**Consultation Response from KC,
Highways Development Management**

2024/93227 land at, St Luke's, Bierley Marsh, East Bierley, BD4 6PL

**Variation condition 2 (plans) on previous permission 2020/94345 (APP/Z4718/W/21/3289729) for
erection of 5 dwellings**

client name			
Owens Developments Ltd			
project			
New Dwellings - Land at St Lukes.			
drawing			
Proposed Site Layout			
project number		plot date	
19/157		24/11/20	
drawing number		scale	
104		1:200 @A2	
rev		issue status	
D		Planning Submission

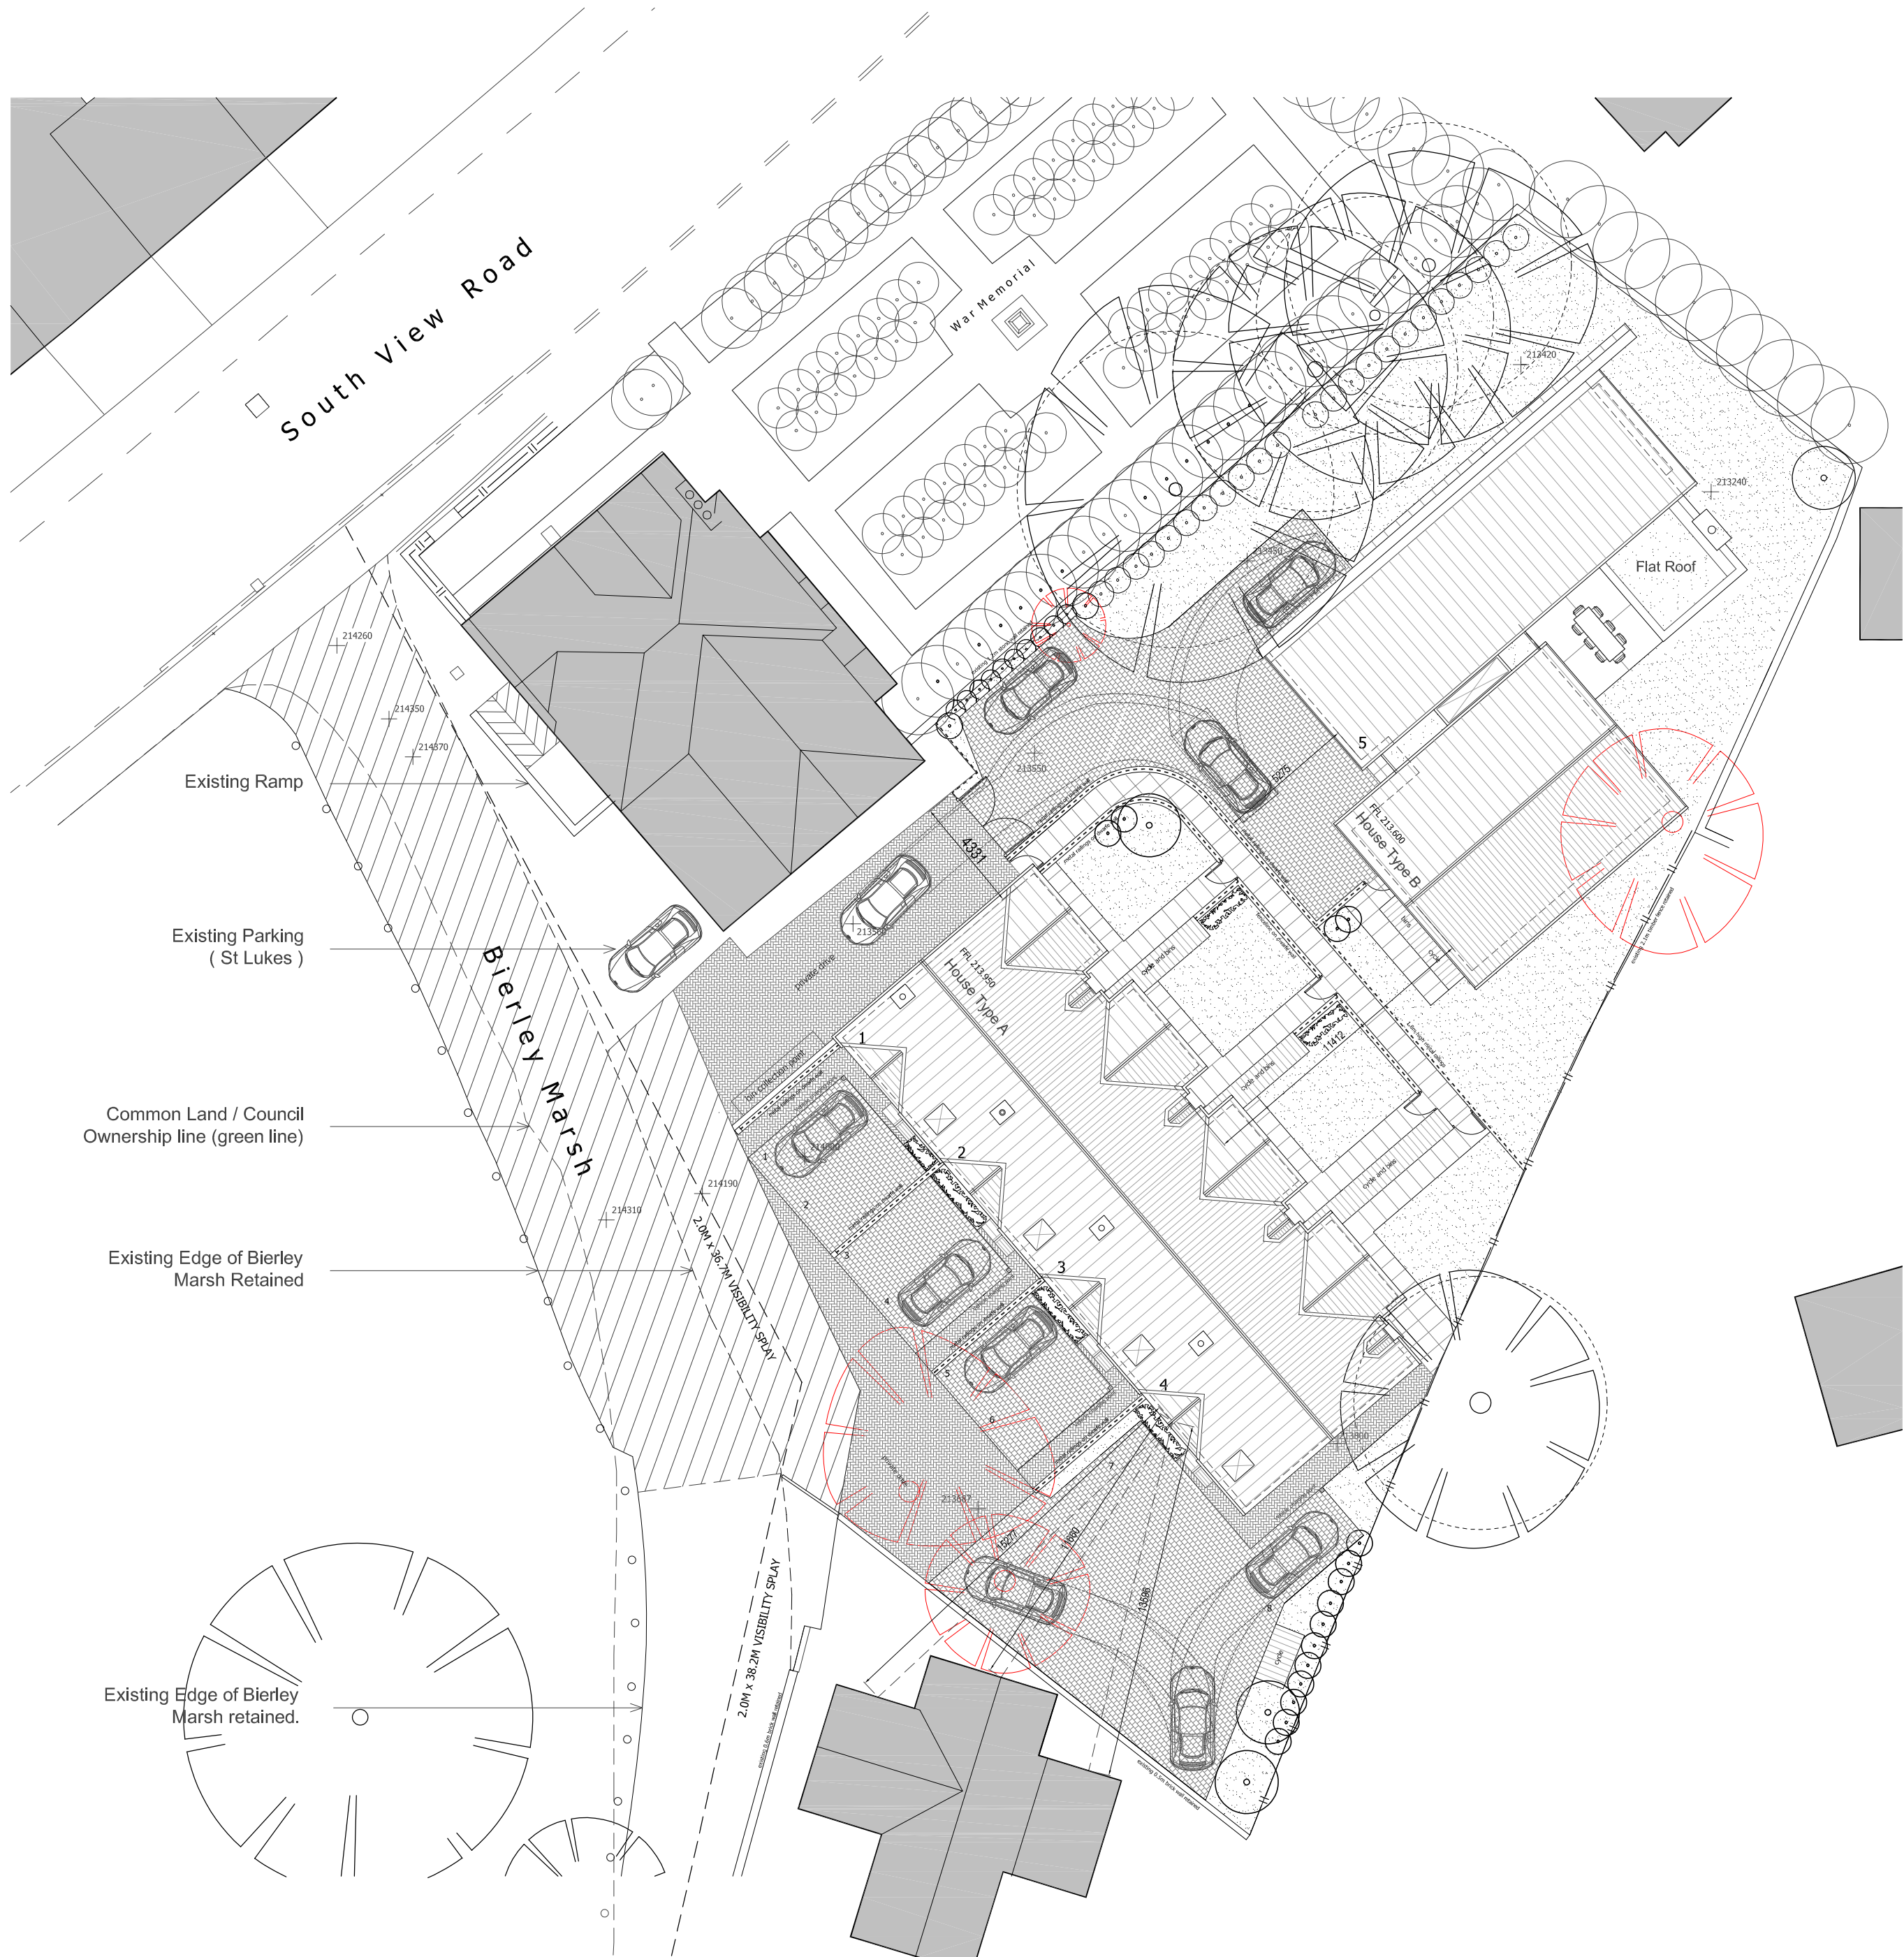
The proposal is to replace plan number 19-157.104B with 19-157.104D.

19-157.104D omits the highway improvements to Bierley Marsh which include the creation of a 5.0m shared surface carriageway.

The proposed variation cannot therefore be considered acceptable to Highway Development Management.
